CONSERVATION OFFICER PLANNING CONSULTATION

Reference Number: H17-0503-26

Proposal: Demolition of existing building and re-location of existing access - Part Retrospective

Location: Rear of The Mermaid Inn, 2 Gosberton Road, Surfleet, PE11 4AB

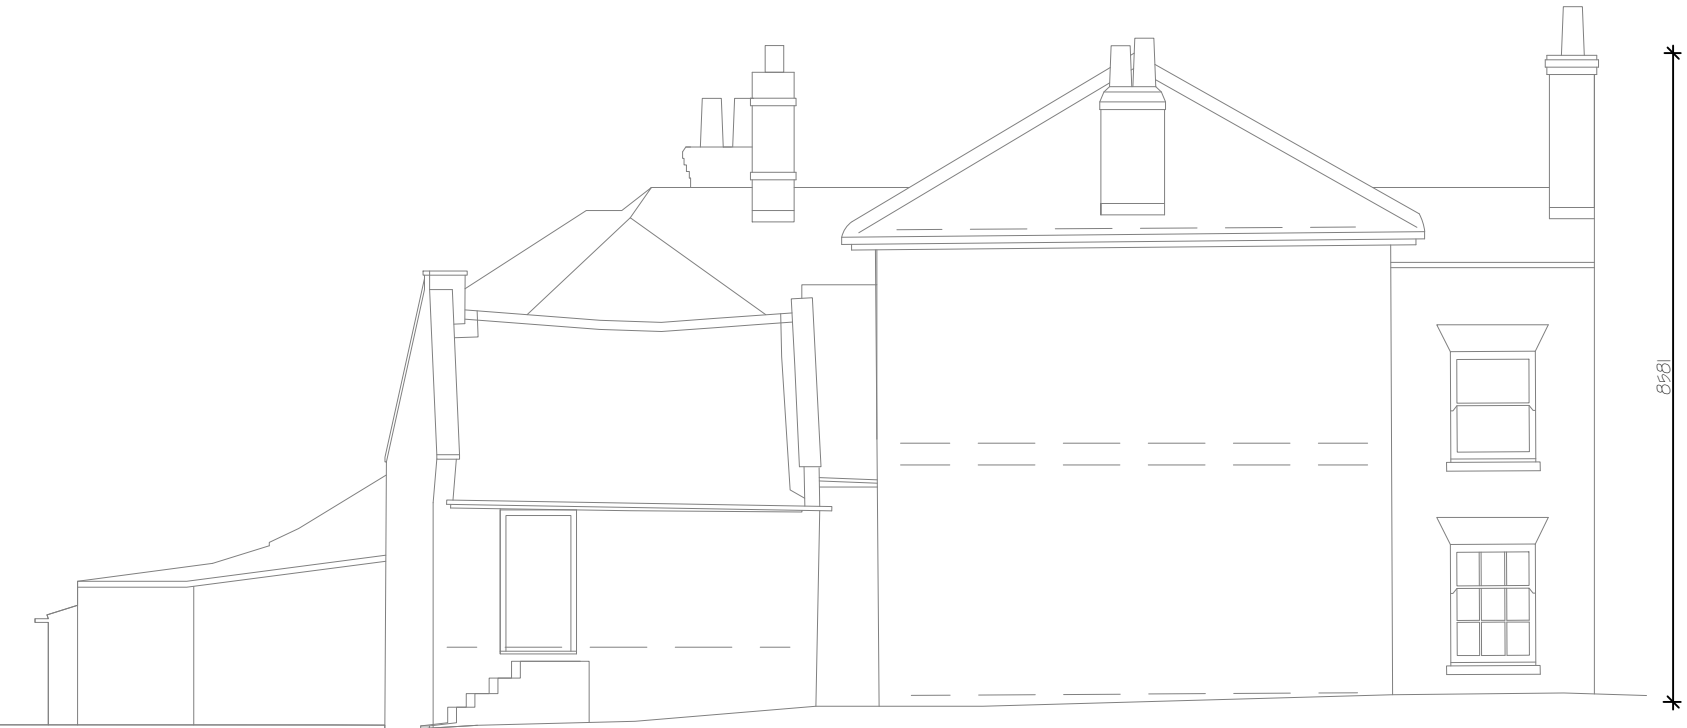
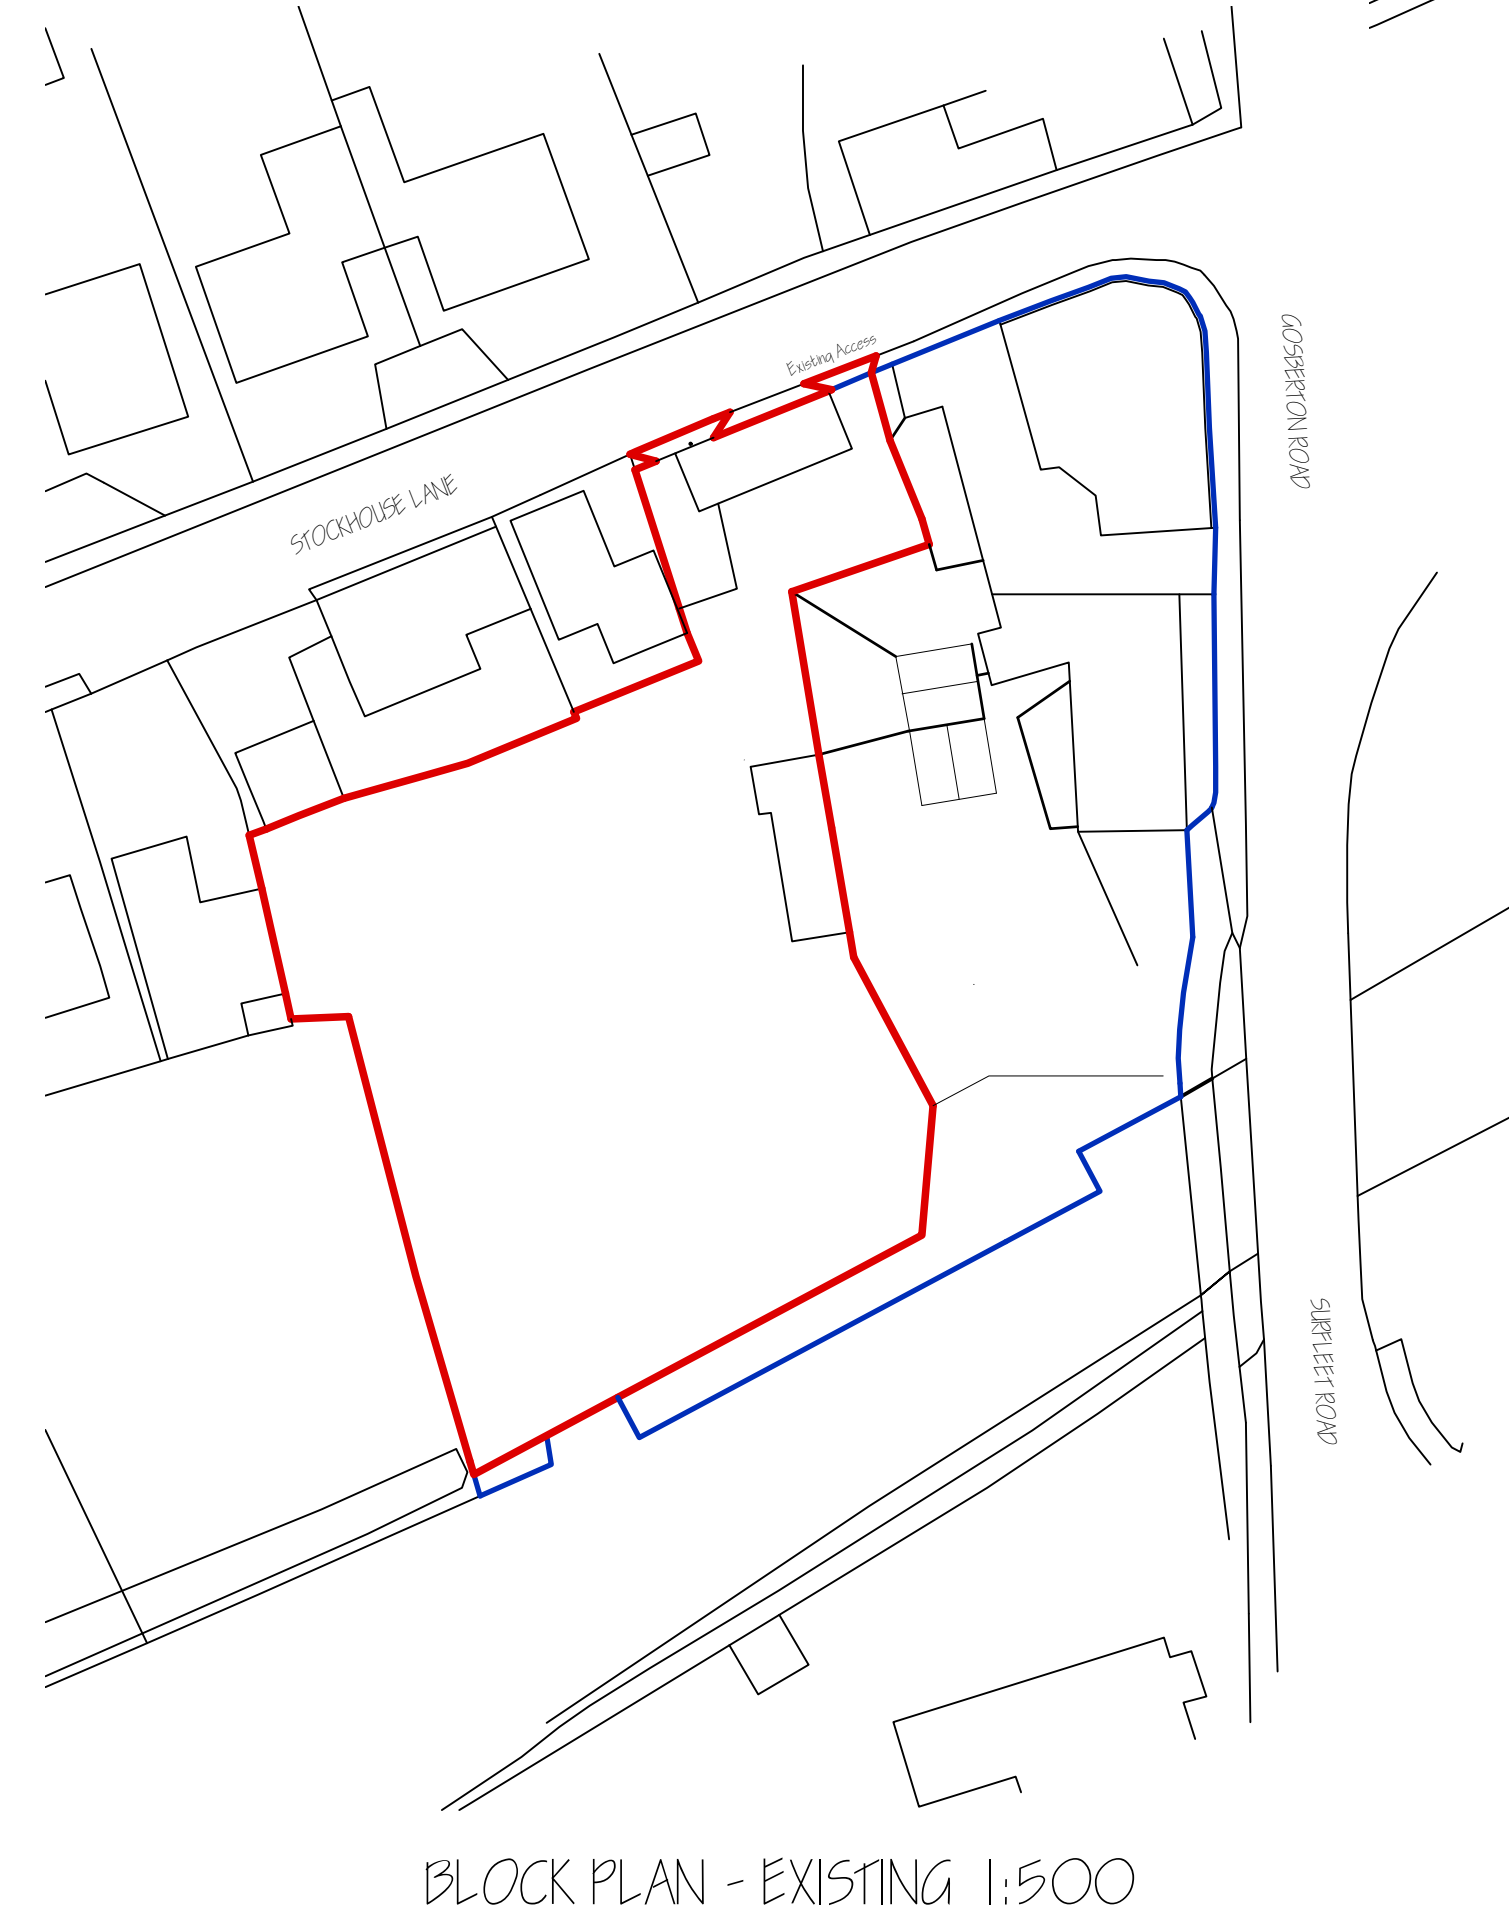
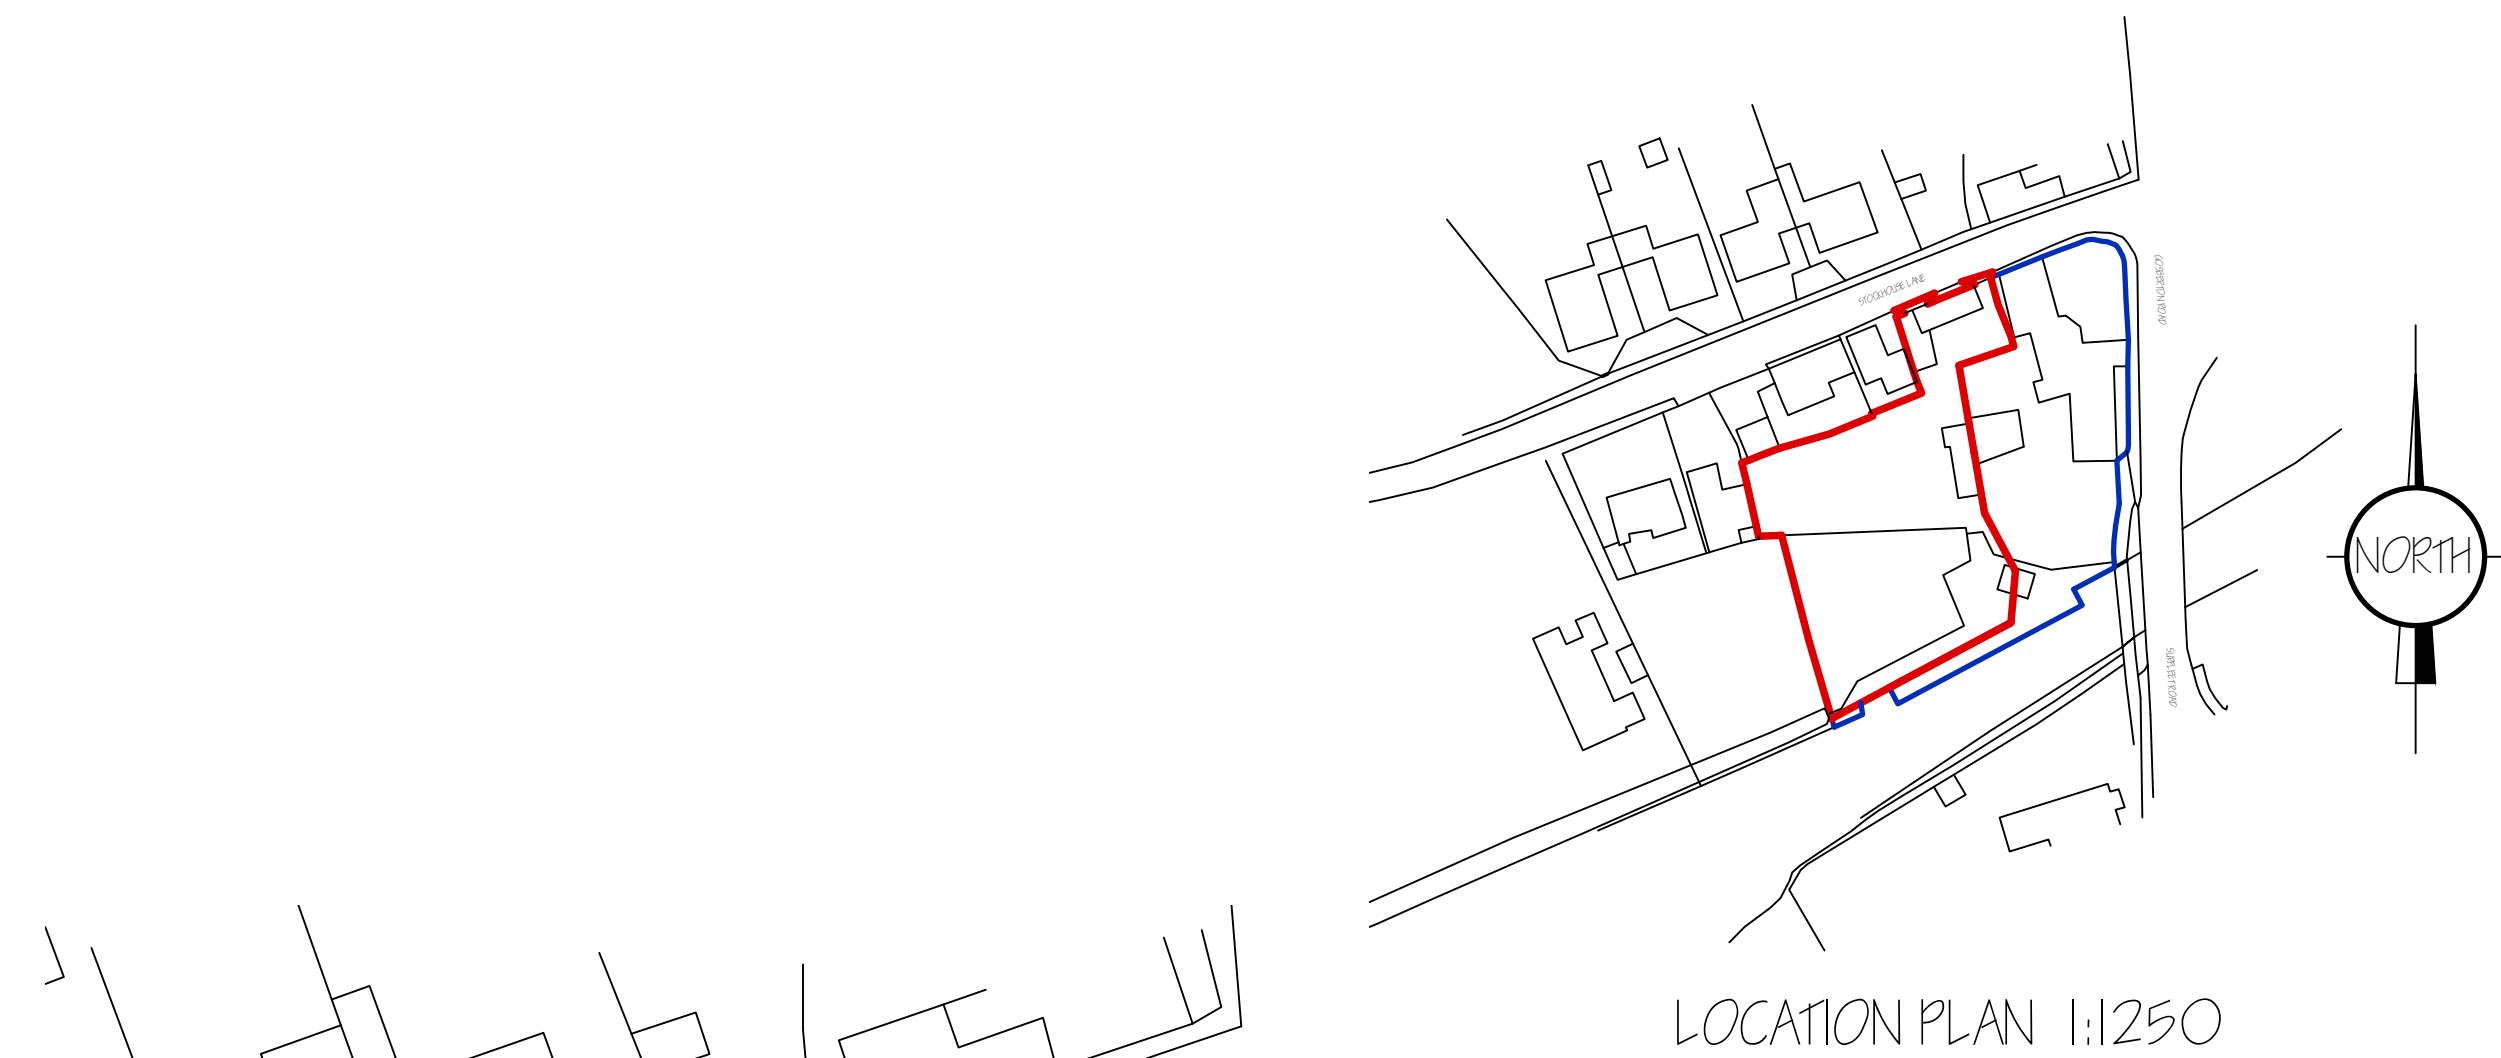
Regarding the housing development to the south side of the site, consisting of x2 large independent dwellinghouses; I do not object to the principle of the proposal, nor to the basics of the design. However, I do have concerns about the materials proposed to be used throughout the development. The previous scheme consented on this site proposed natural timber boarding, as well as white painted timber windows and doors, which I believe led to a softer appearance that sat better within its setting.

I think perhaps we have lost a little sight of the fact that this is a significant development directly in the curtilage of a listed building, and as such, respect must be paid to the quality of materials to be proposed throughout. I would therefore request that the application be amended to remove the cedar boarding to be replaced with genuine timber (shiplap boarding may be locally appropriate).

In addition, I also believe that the structure would be better served by white, timber windows similar to those approved under the previous scheme, however, rather than confirming right now that this is a necessity, I think a mock up of this would be beneficial to see before a final consultation.
